Application Ref:	3/2026/0408			 Ribble Valley Borough Council www.ribblevalley.gov.uk
Date Inspected:	N/A	Site Notice:	N/A	
Officer:	AR			
DELEGATED ITEM FILE REPORT:				REFUSED

Development Description:	Certificate of lawfulness for proposed rear and side single-storey extensions and rear dormer.
Site Address/Location:	125 Whalley Road Read BB12 7RP

Consent is sought for a Certificate of Lawfulness for the construction of a rear extension, side extension and a rear dormer.

PROPOSED PLANS AND
ELEVATIONS

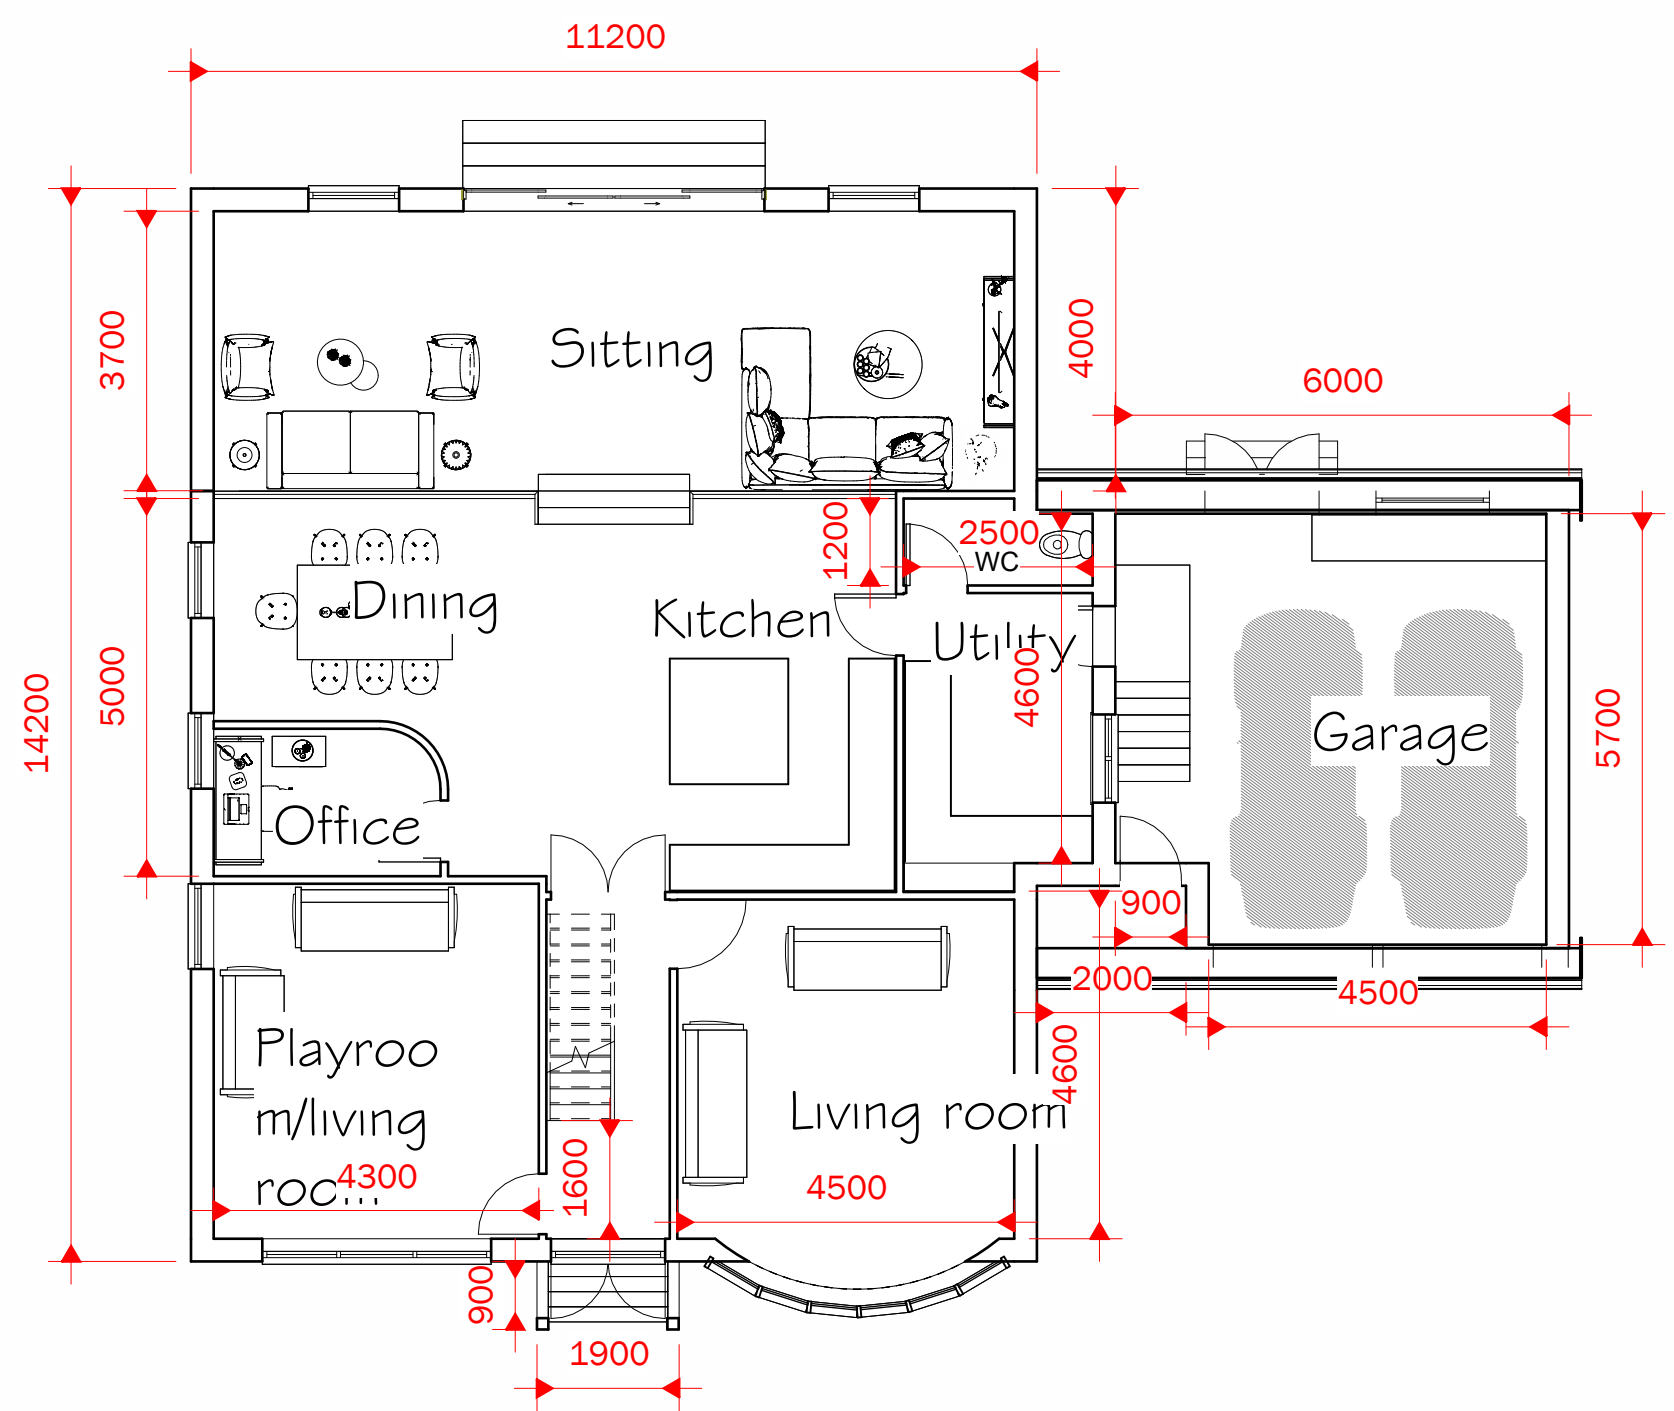
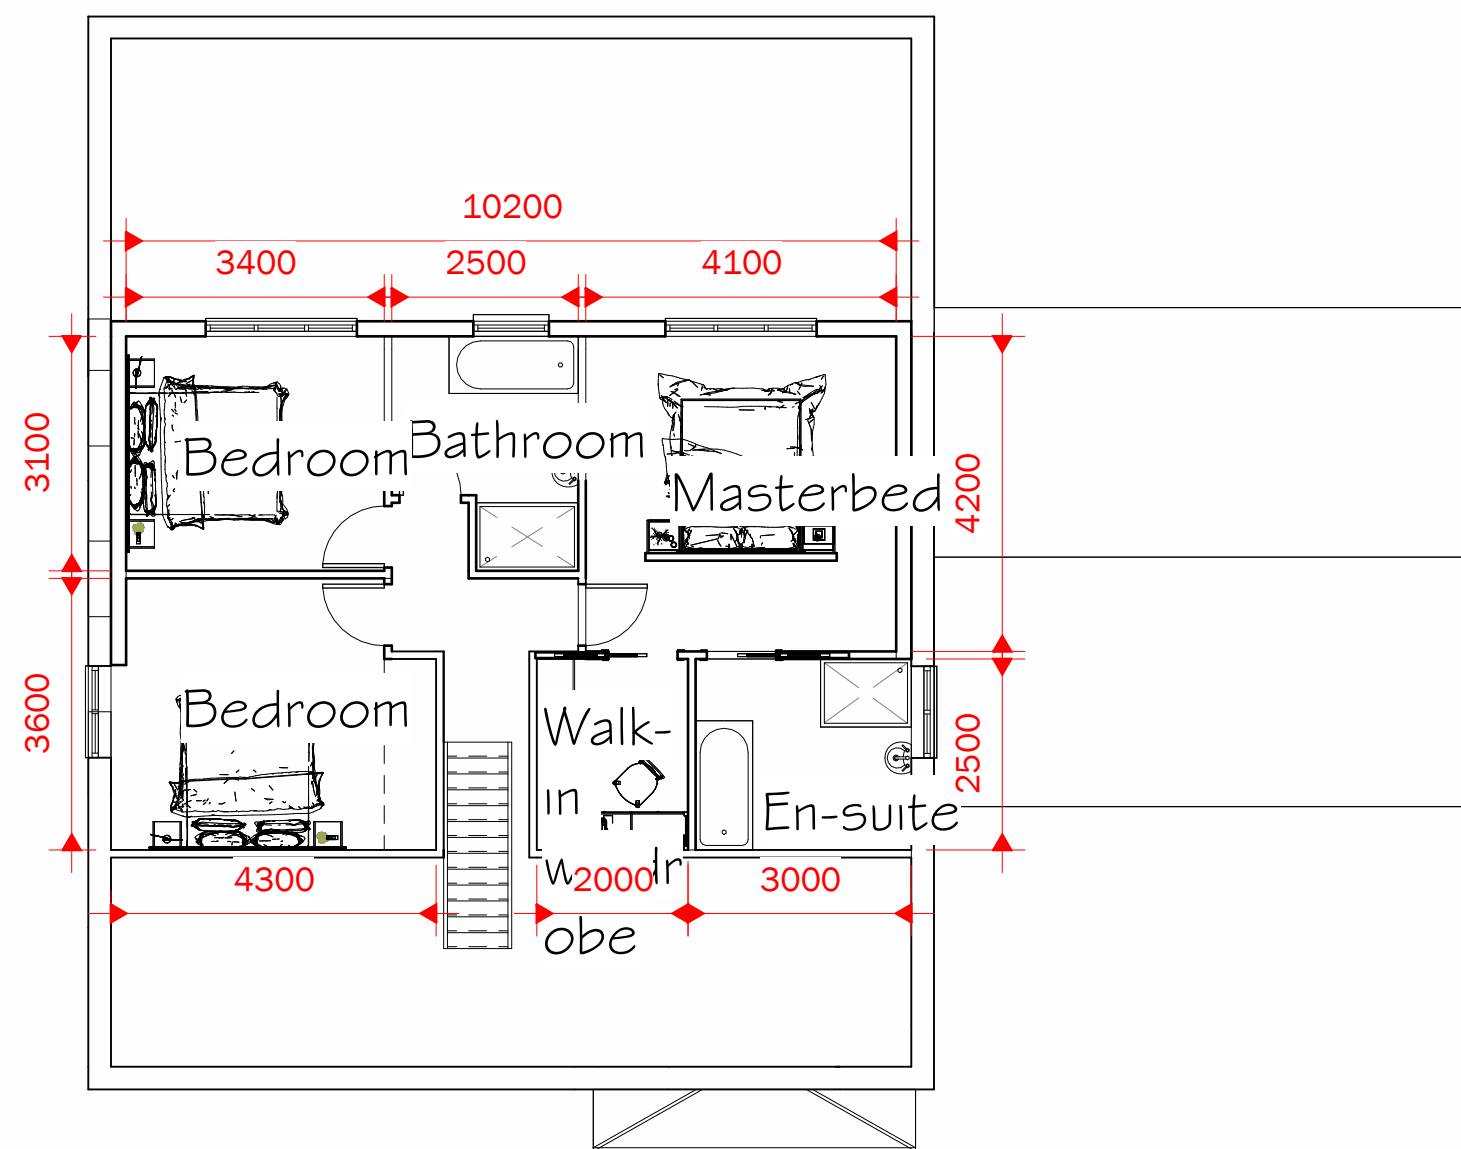
The proposed enlargement(s) would extend beyond a wall which fronts a highway and forms a side elevation of the original dwellinghouse.

Insufficient details have been provided to prove the proposal complies with the above. Since, the proposal fails to comply with other criterion at e) (ii) and j) (iii) then further details to show compliance with this element have not been requested.

The enlarged part of the dwellinghouse would extend beyond a wall forming a side elevation of the original dwellinghouse and would have a width greater than half the width of the original dwellinghouse.

Insufficient details have been provided to prove the proposal complies with the above. Since the proposal fails to comply with the criteria for Class A, further details have not been requested.

The proposed works do not constitute permitted development under The Town and Country Planning Act (General Permitted Development) (England) Order 2015, Schedule 2, Part 1, Class A, as the proposal fails to comply with paragraphs (e) and (j).

Furthermore, insufficient details have been provided to prove the proposal complies with paragraph (i) of Class A and paragraph (d) of Class B of The Town and Country Planning Act (General Permitted Development) (England) Order 2015 Schedule 2, Part 1.
